Case reference: PAX91.323780

Ballinlee Wind Farm – Dooley Family Submission

Date: 16th November, 2025

Figure 2-5: Proposed Turbine Delivery Route.

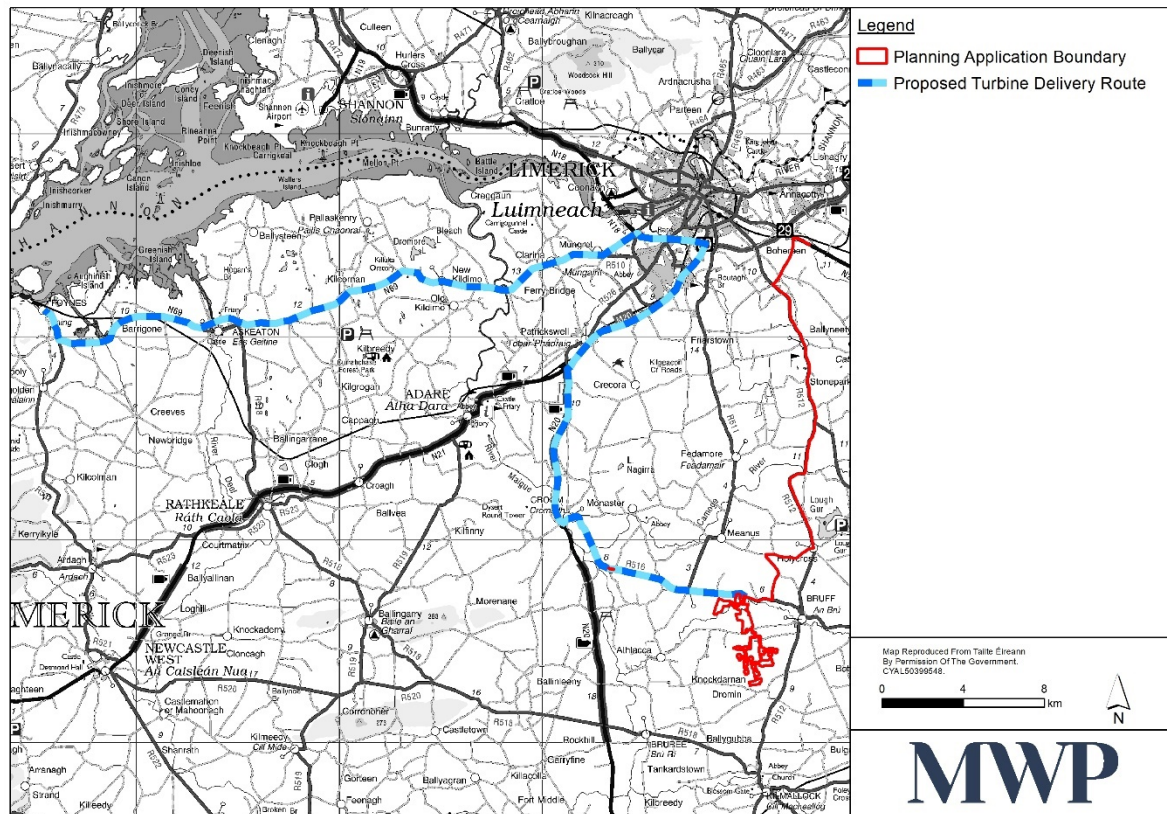
An Bord Pleanála explicitly requested, at pre-planning meetings in November 2024 and March 2025, that the applicant provide detailed consideration of alternatives for both grid connection and turbine delivery routes. These directions were not substantively acted upon. Appendix 2C (Turbine Delivery Route Report) defers assessment of the Adare Bypass (Foynes Road) route to a future stage. This is contrary to EIA requirements that reasonable alternatives be assessed before consent.

of the meeting. Yet, the turbine delivery alternatives remain deferred pending the completion of the Adare Bypass. This means the project's logistical footprint is undefined. See Fig. below:

Figure 2-17: OSI Borrow Pit Locations

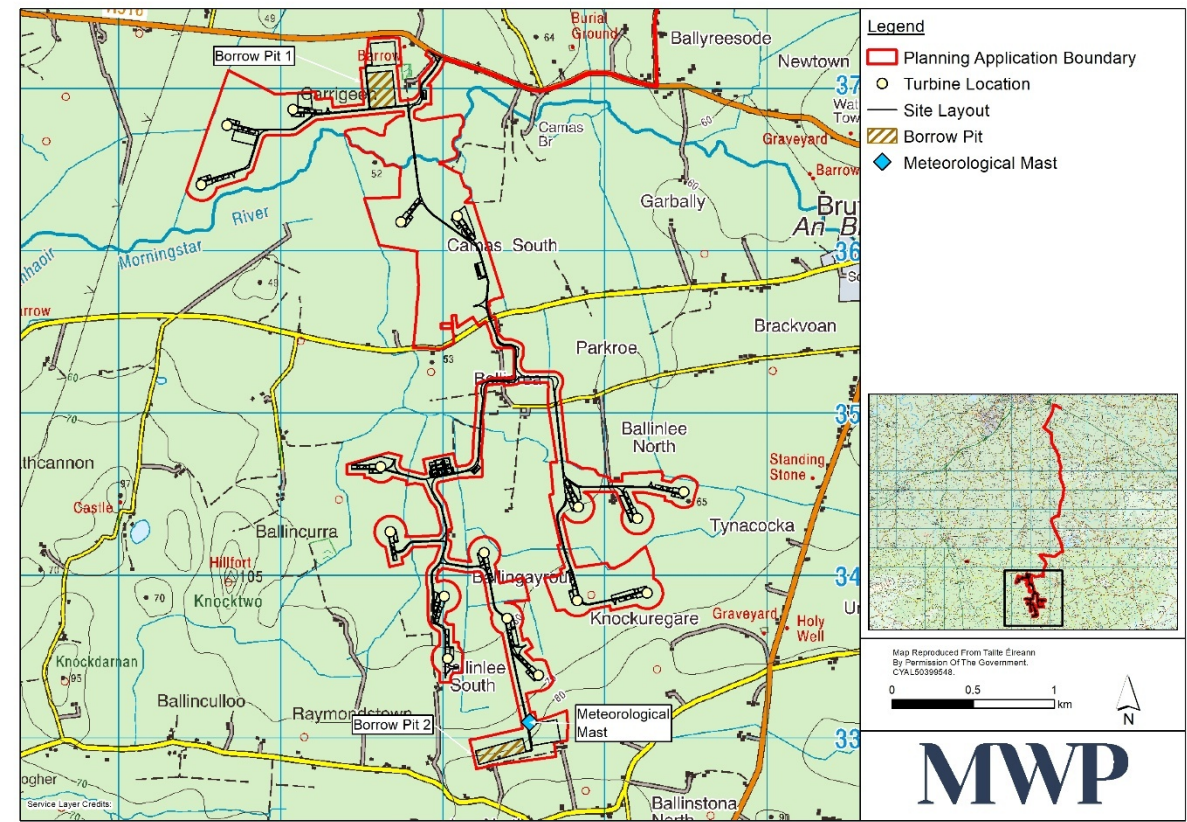
The developer claims that this site is a suitable location for two large-scale quarry sites to supply 61% of the aggregate required for the development, amounting to 99,852m³ (or

4,992 HGV loads at 20m³ per load). This claim is based on very limited trial pit data, without any rock core drilling to assess the extent of bedrock and with no assessment of the quality of aggregate actually available. Therefore, the developer's claims do not bear scrutiny and if allowed to proceed, risk critical hydrogeological impacts.

Furthermore, the character of the soils in Appendix 8B consistently shows a predominantly topsoil, followed by silts and heavy clay. The developer offers nothing by way of independently verified reassurance that this material is fit for purpose. We regard this as a significant omission that casts doubt over the viability of the project and the claims in other sections of the EIAR, reliant on the viability of the on-site quarries.

At the very least, we believe a robust hydrogeological survey is necessary to validate the notion that it is feasible to position two large-scale quarries in this area. We believe that using an unverified assumption to justify a preferred site selection demonstrates a reliance on circular reasoning to align with the developer's approach of using the EIA to justify the windfarm location and design rather than as an informed basis for location and design decision-making. We believe this exemplifies the developer's lack of due regard for the local area, its environment and its residents.

Figure 3-13: Grid Connection Options Considered

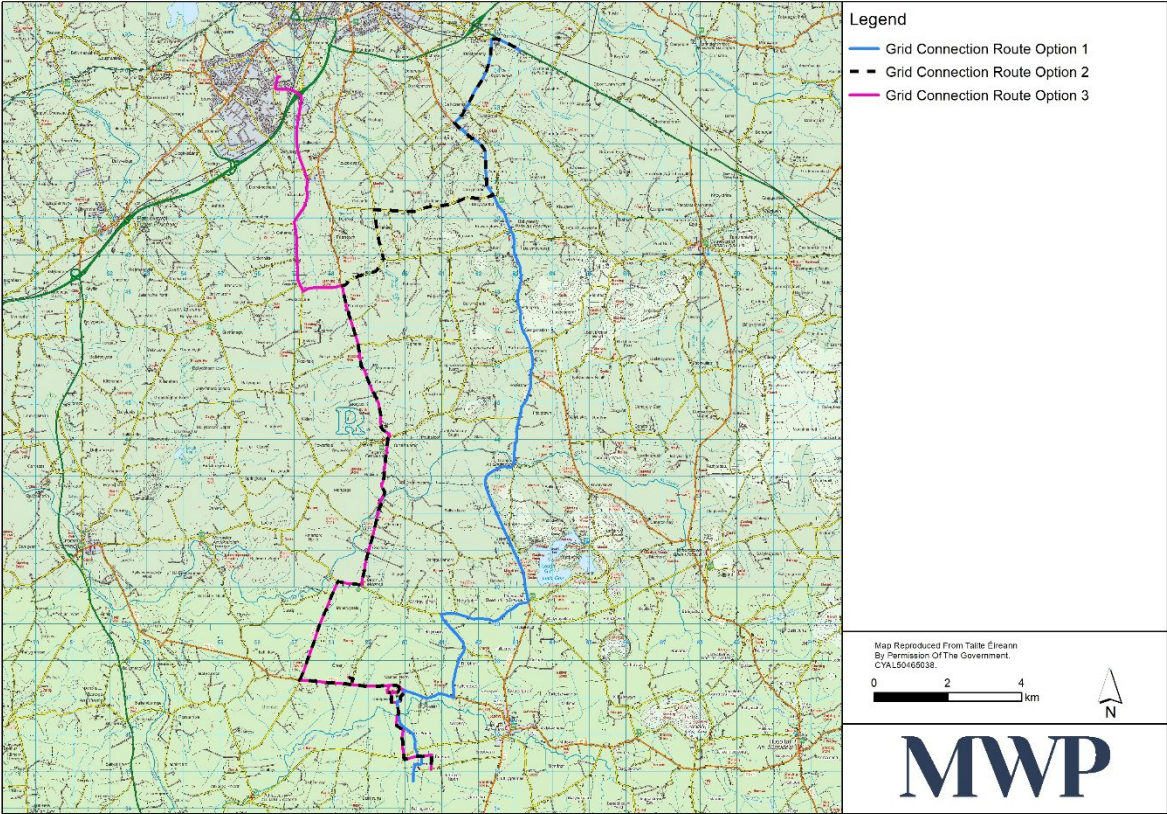
The longest grid connection route (27.6 km to Killonan substation) was selected over a shorter (25 km) alternative to Limerick, with no quantitative justification. This decision carries material environmental and cost implications and was raised as an issue at the preplanning meeting with An Bord Pleanála on 20th March 2025, as recorded in the memo

Figure 8-15: Trial Pit Positions

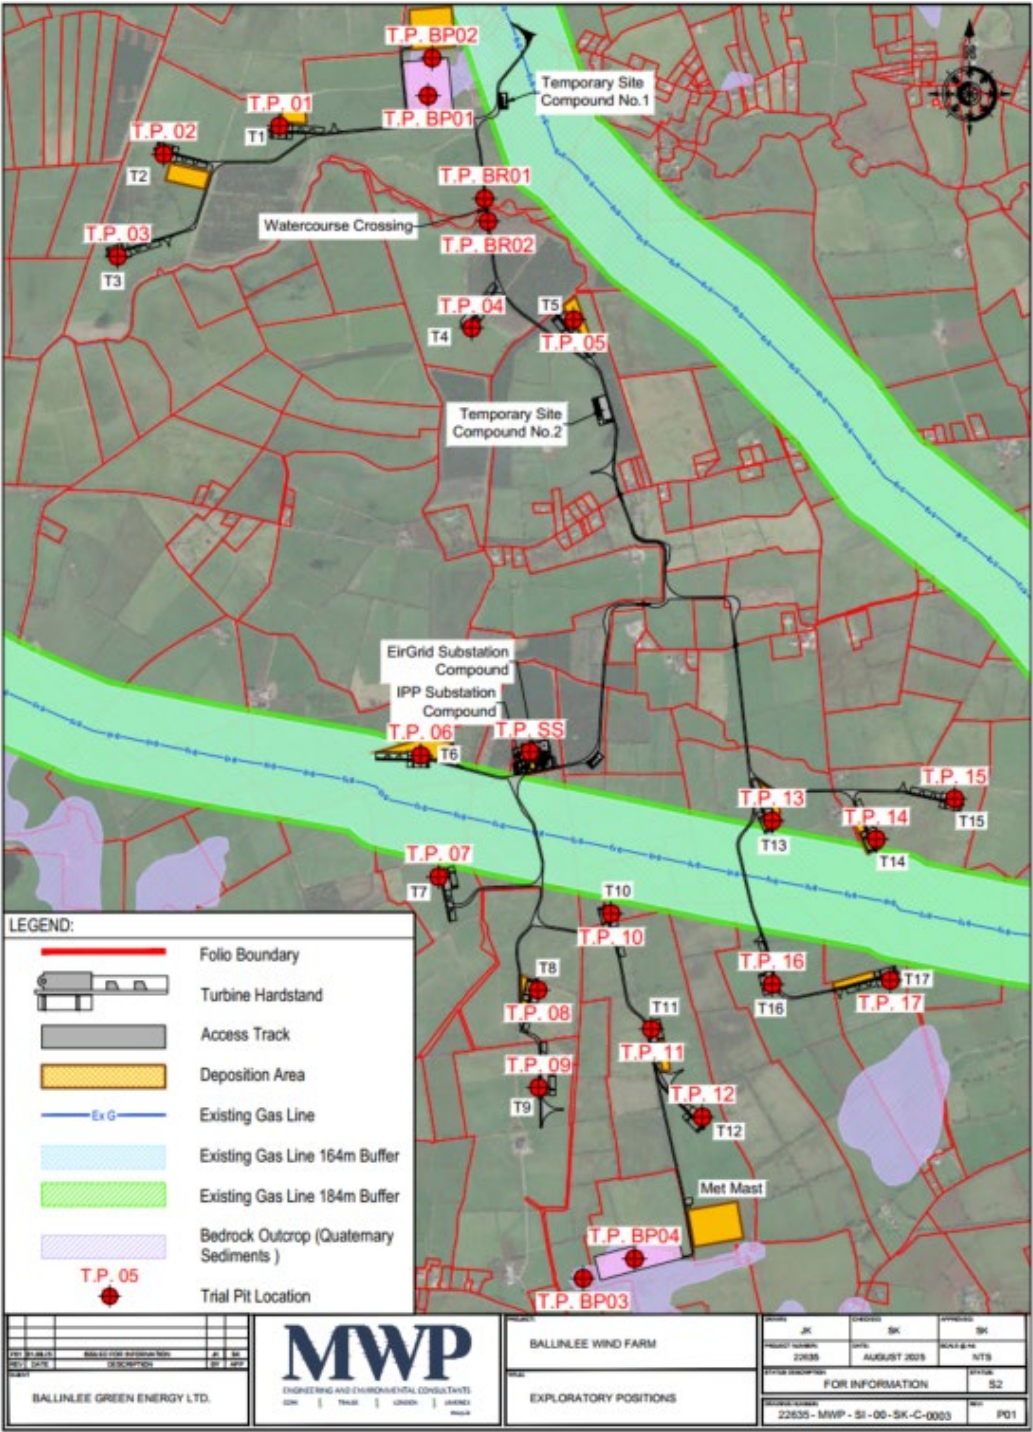
To demonstrate the limited research on which the developer's claims rest, see the figure below, taken from Appendix 8B. Of the potential sites investigated on February 7th, 2025, groundwater was evident at 50%. The depths at which water seepage became evident were at ranged from 1m below ground level to 2.3m below ground level (see example at Fig. 1).

Figure 1: Developer trial pit data showing water ingress at 1m below ground level
